## PLANNING CONSULTATION RESPONSE

<b>Application No</b>	2025/1075
<b>Proposal</b>	Change of use from a 6 person HMO (Class C4) to an 8 person HMO (Sui Generis).
<b>Address</b>	61 Longman Road, Barnsley, S70 2LD
<b>Date of Consultation Reply</b>	07.01.26
<b>Consultee</b>	Stacey Fieldsend-Case Management Officer

PROPOSED FLOOR PLANS
SCALE 1:100 @ A3
REV D

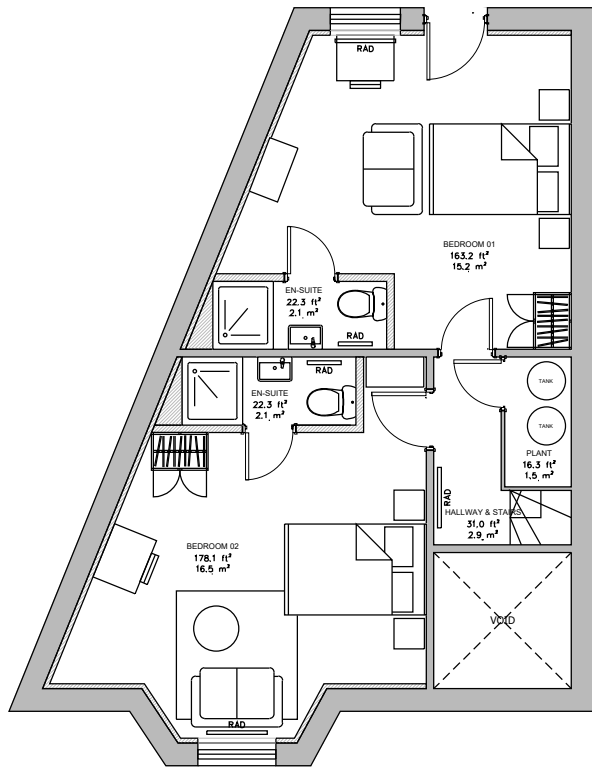
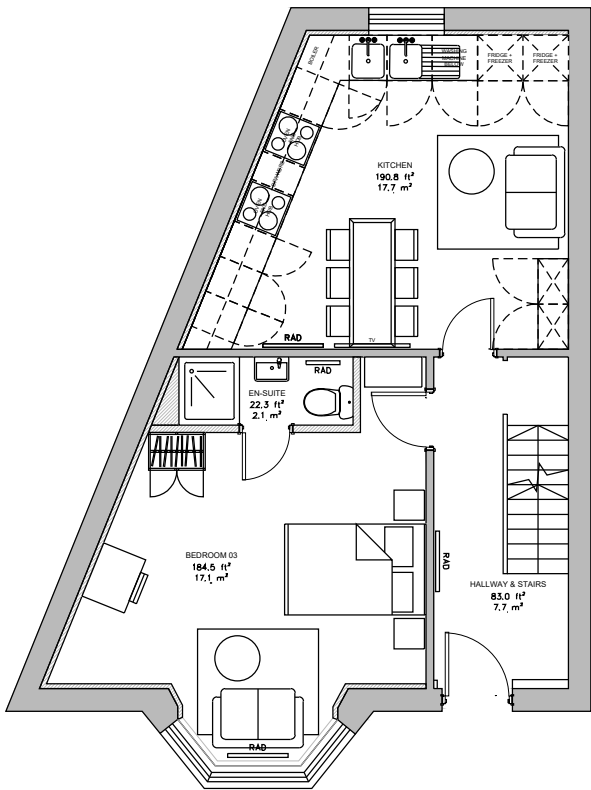
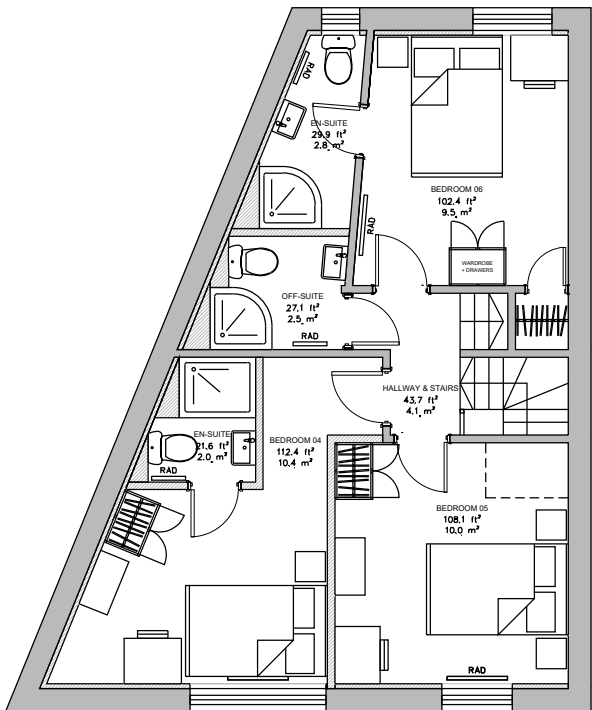
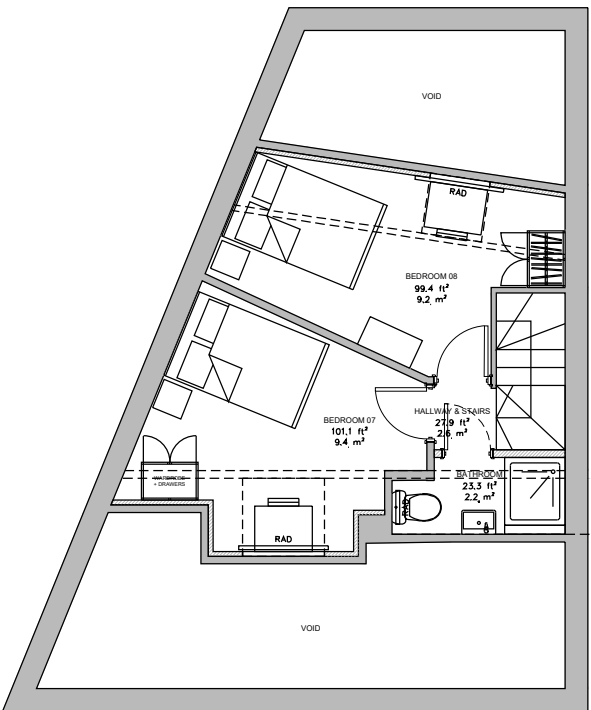
Room 1 is suitable for a couple sharing, however as the property does not have a separate living room the remaining five rooms are only suitable for single occupancy due to room sizes being under 15sq metres.

In line with the proposed plans, I would approve a **maximum occupancy of seven people over six** households.

The rooms within the lower ground floor of the property are currently unused. I would approve increased occupancy to eight if one of the basement rooms are converted to a living room. This would permit double occupancy of Rooms 1 & 2 with single occupancy of the remaining four rooms. Alternatively, one of the basement rooms could be converted to a sleeping room allowing double occupancy of room 1 & single occupancy of the remaining six rooms.
